Application by Able Humber Ports Ltd for Able Marine Energy Park Material Change 2

The Examining Body's written questions and requests for information (ExQ2)

ExQ2: 13 January 2022

PLANNING			
Scale:	Drawn By:	Checked By:	Approved By:
NTS@A1	D Almeida	R Crum	R Crum
Date:	07/12/2020	12/02/2021	12/02/2021
Drawing No:	AME-036-10010	Revision:	C

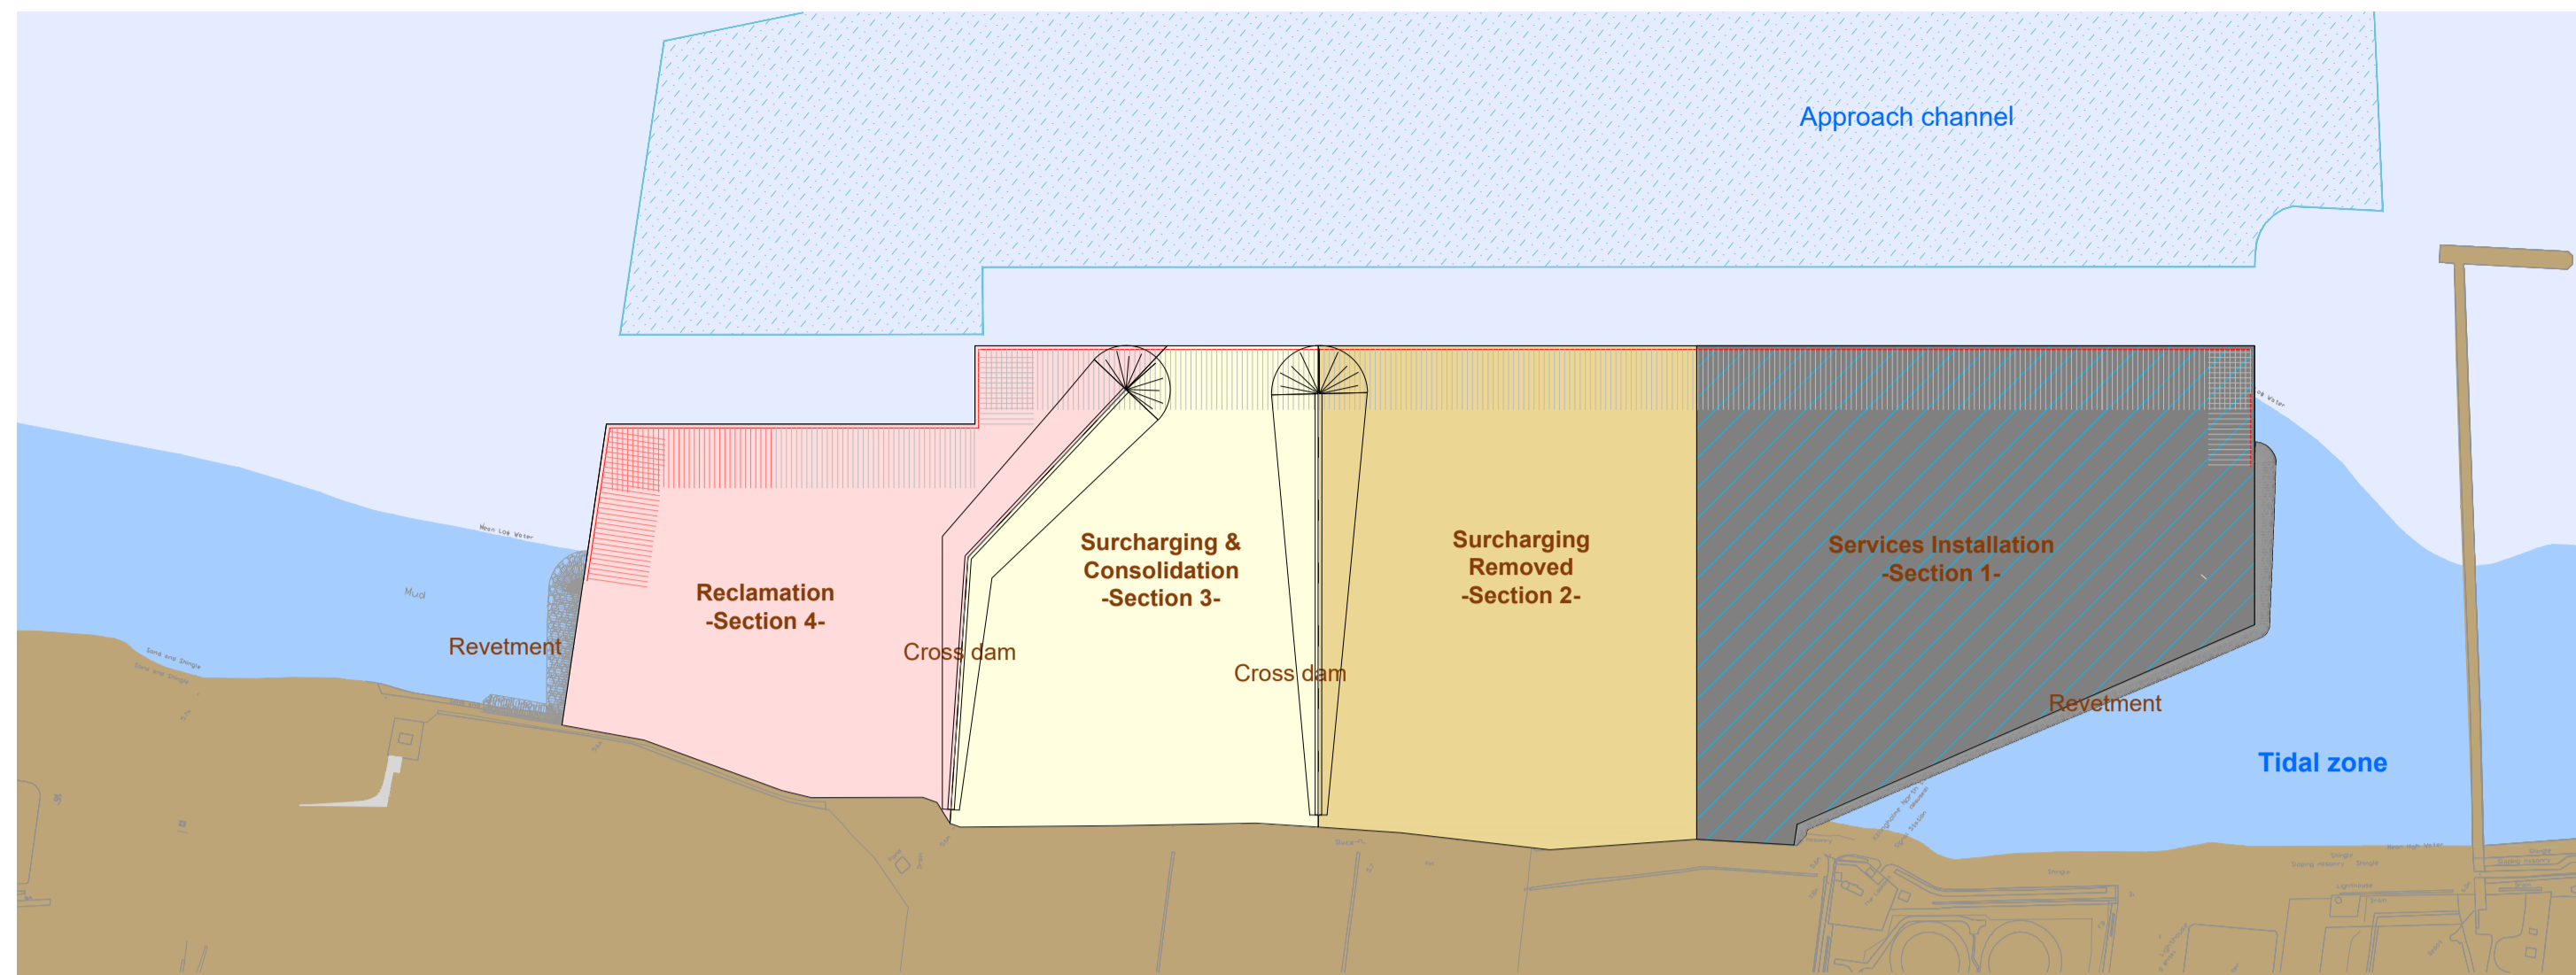
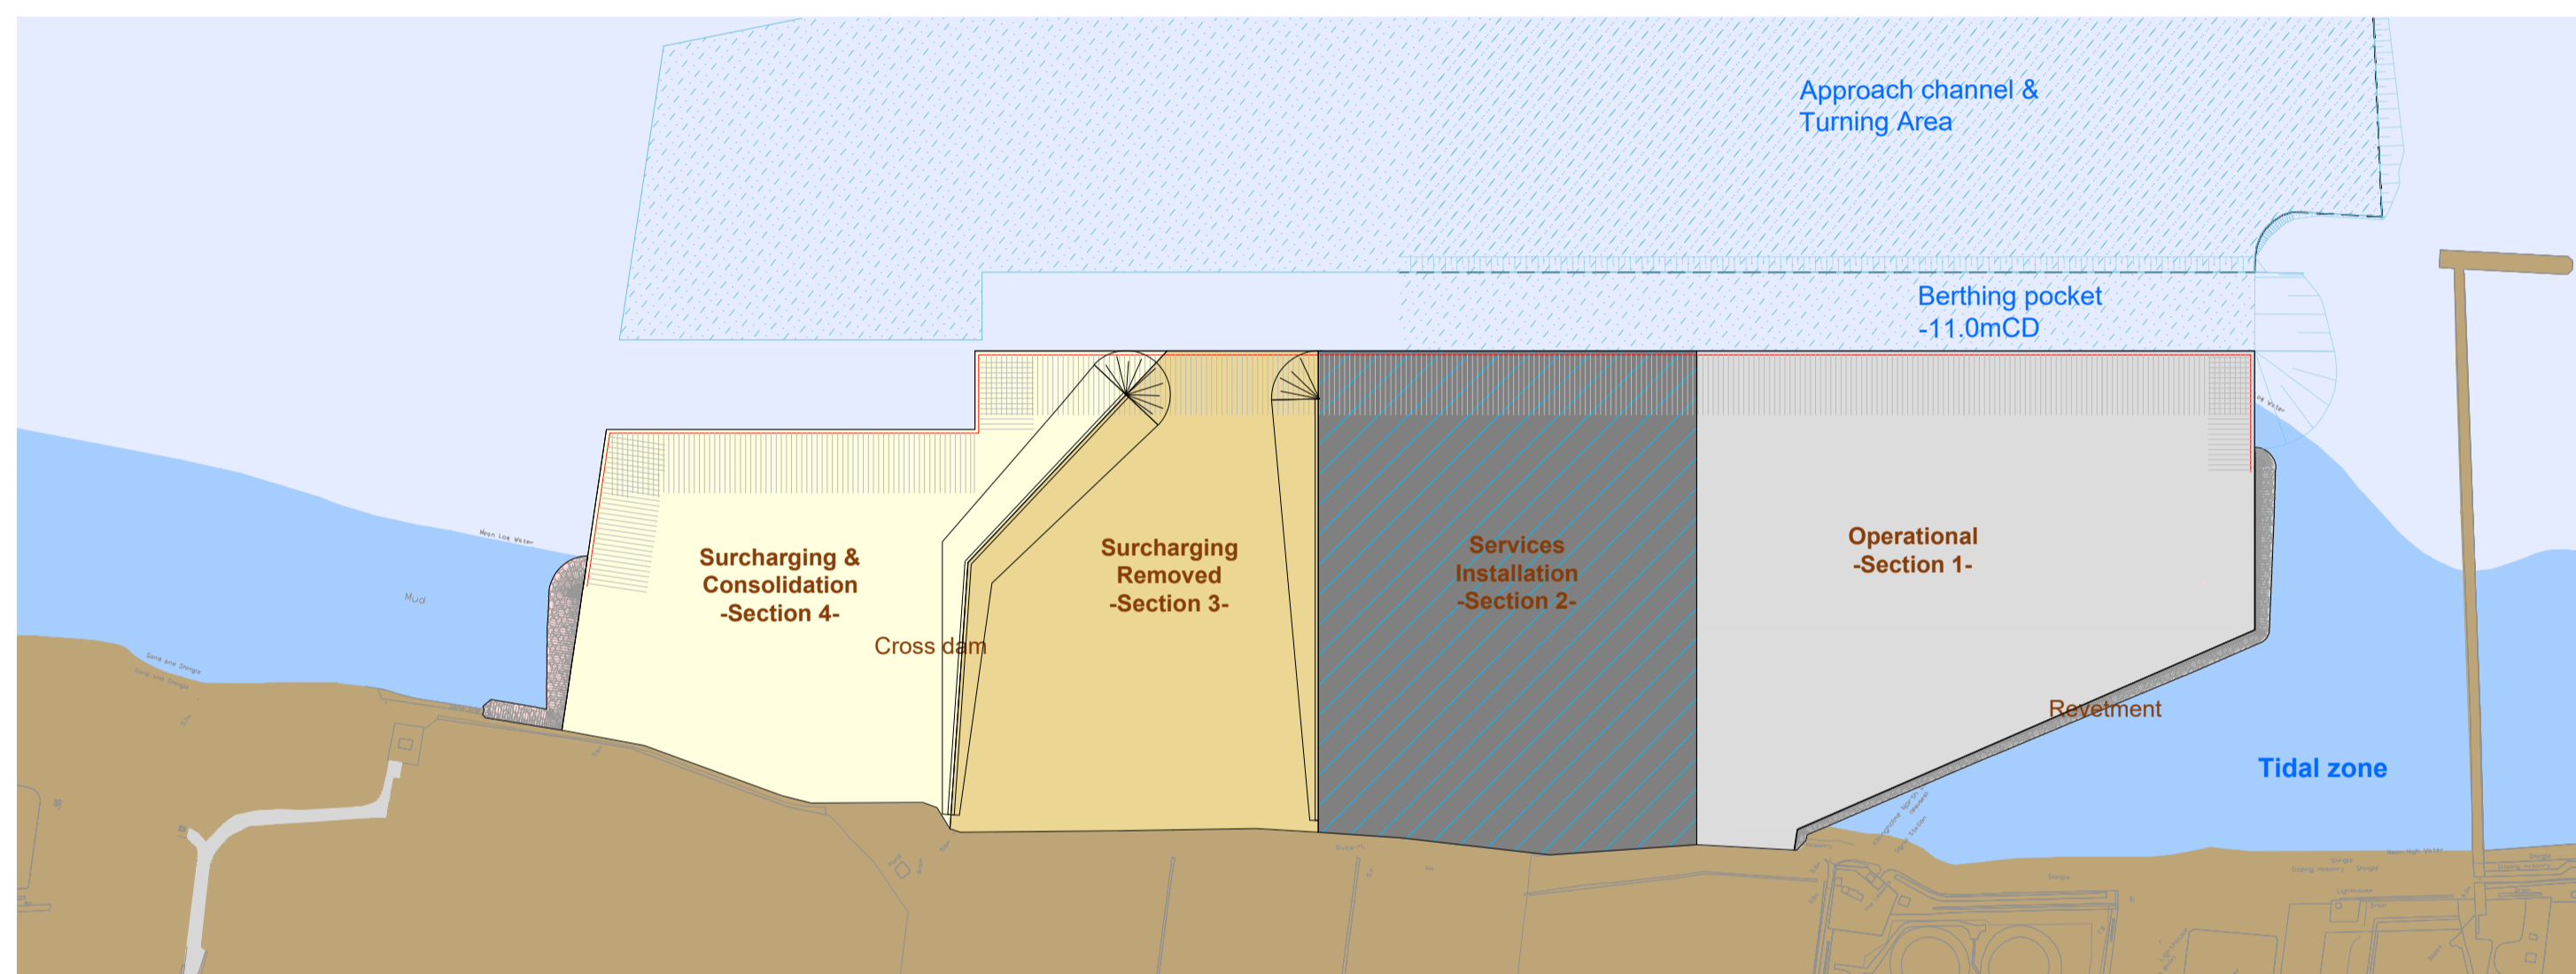
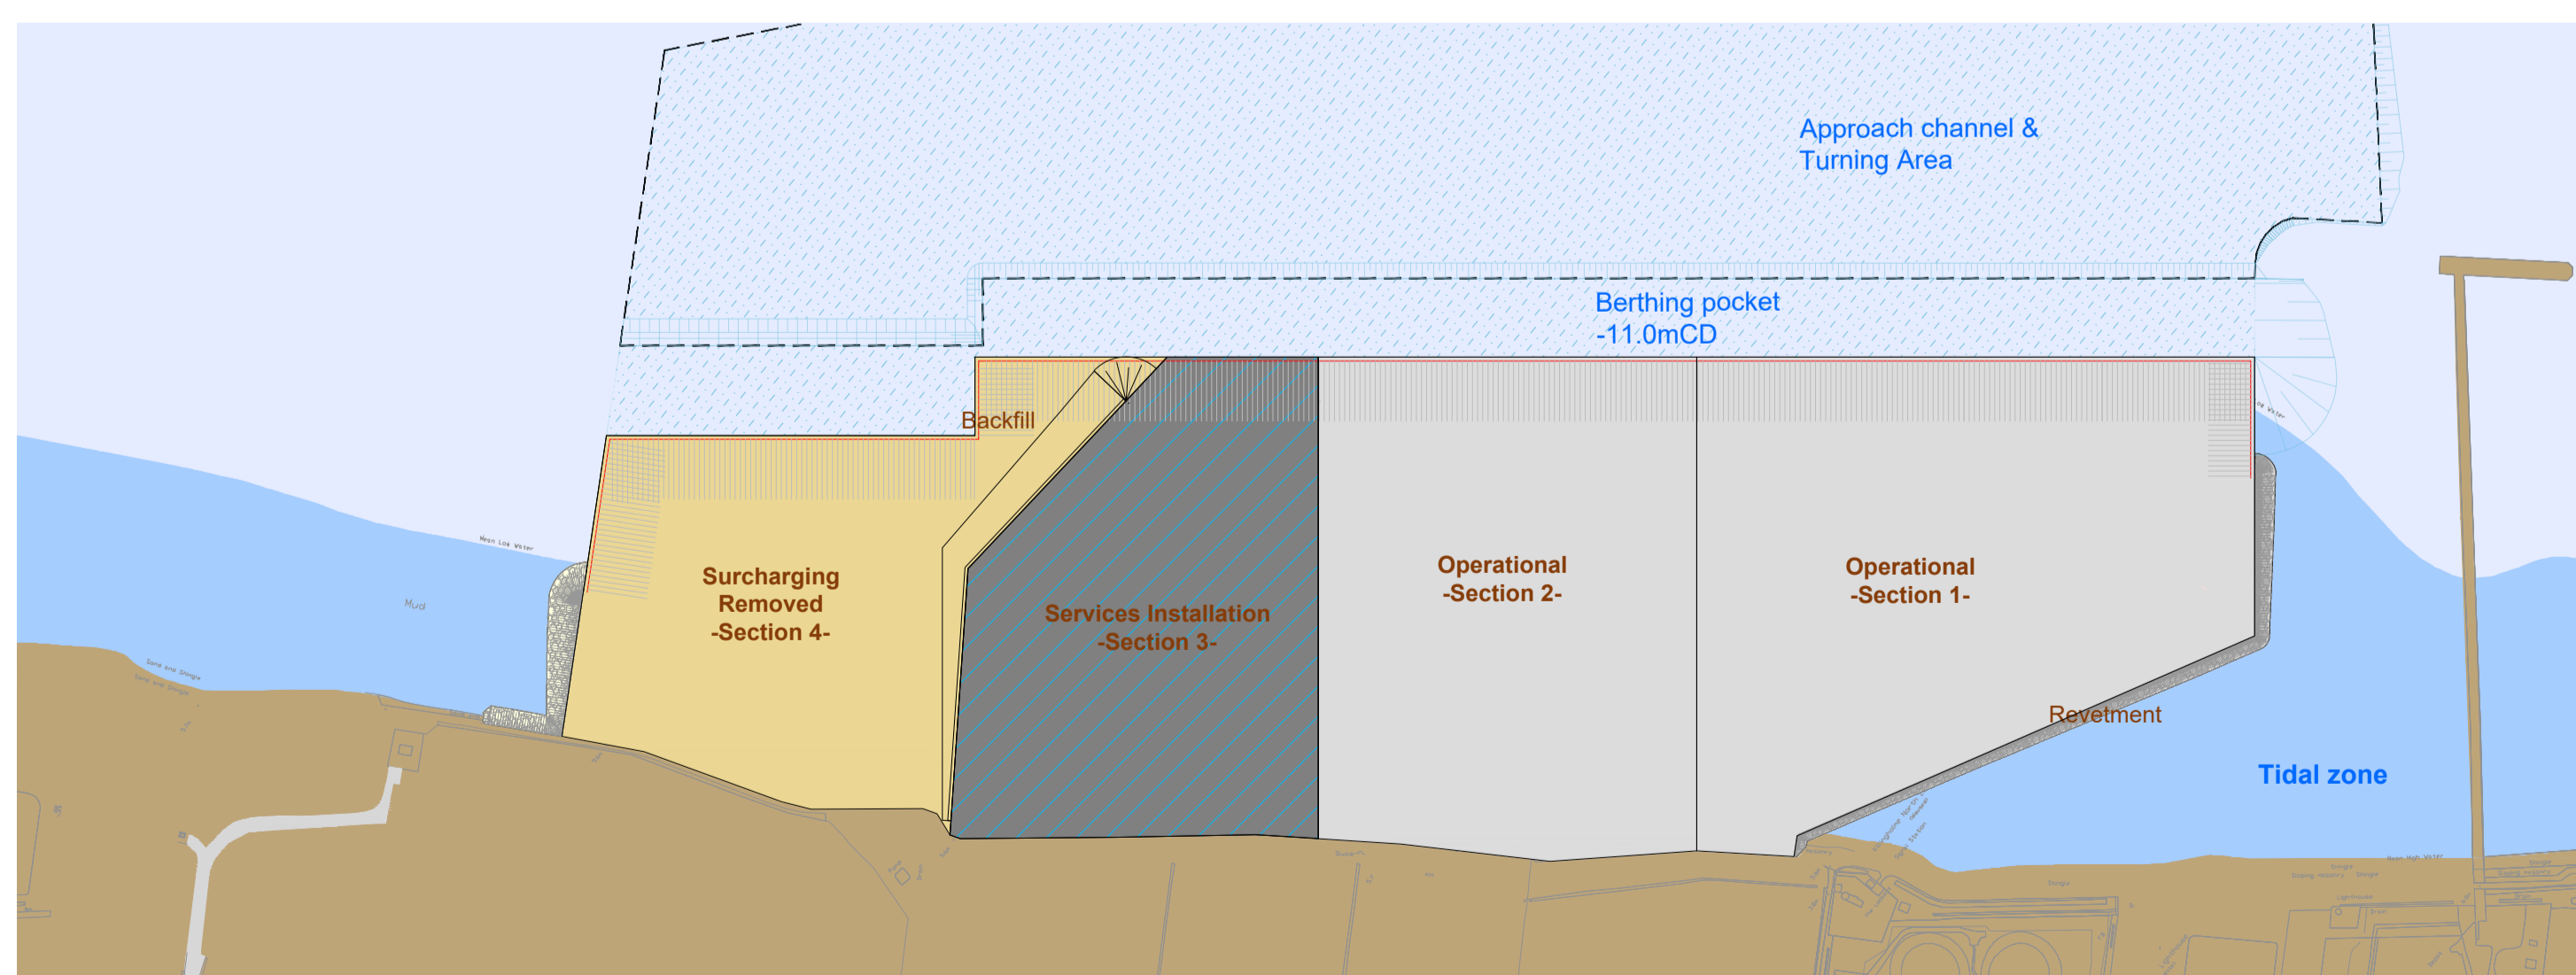
ExQ2	Question to:	Question:
1. General and Cross-topic Questions		
Q1.01	App	<p>Pease supply A3 size copies of drawings AME-036-10009 rev C and AME-036-10010 rev C.</p> <p>These were previously supplied as A1 size copies when A3 size was requested. (The ExB already has AME-036-10011 rev C as it applies to both construction process alternatives).</p>
Q1.02	App	<p>Re: ExQ1: 1.0.2, For clarity please confirm whether I am right to interpret drawing AME-036-10004 rev C as showing two prime alternatives -</p> <p><i>A: Anchor piles plus horizontal steel ties to quay piles</i></p> <p><i>B: Flap anchors plus diagonal steel ties to quay piles</i></p> <p>That each of these prime alternatives could be built without a relieving slab or could have one of two types of relieving slab –</p> <p>1: With vertical supporting piles without a crane rail beam</p> <p>2: With vertical piles and some diagonal piles supporting a crane rail beam</p> <p>There would, therefore (noting the Applicant’s response to ExQ1:1.0.3), be six overall alternatives – A, A1, A2, B, B1, B2.</p>
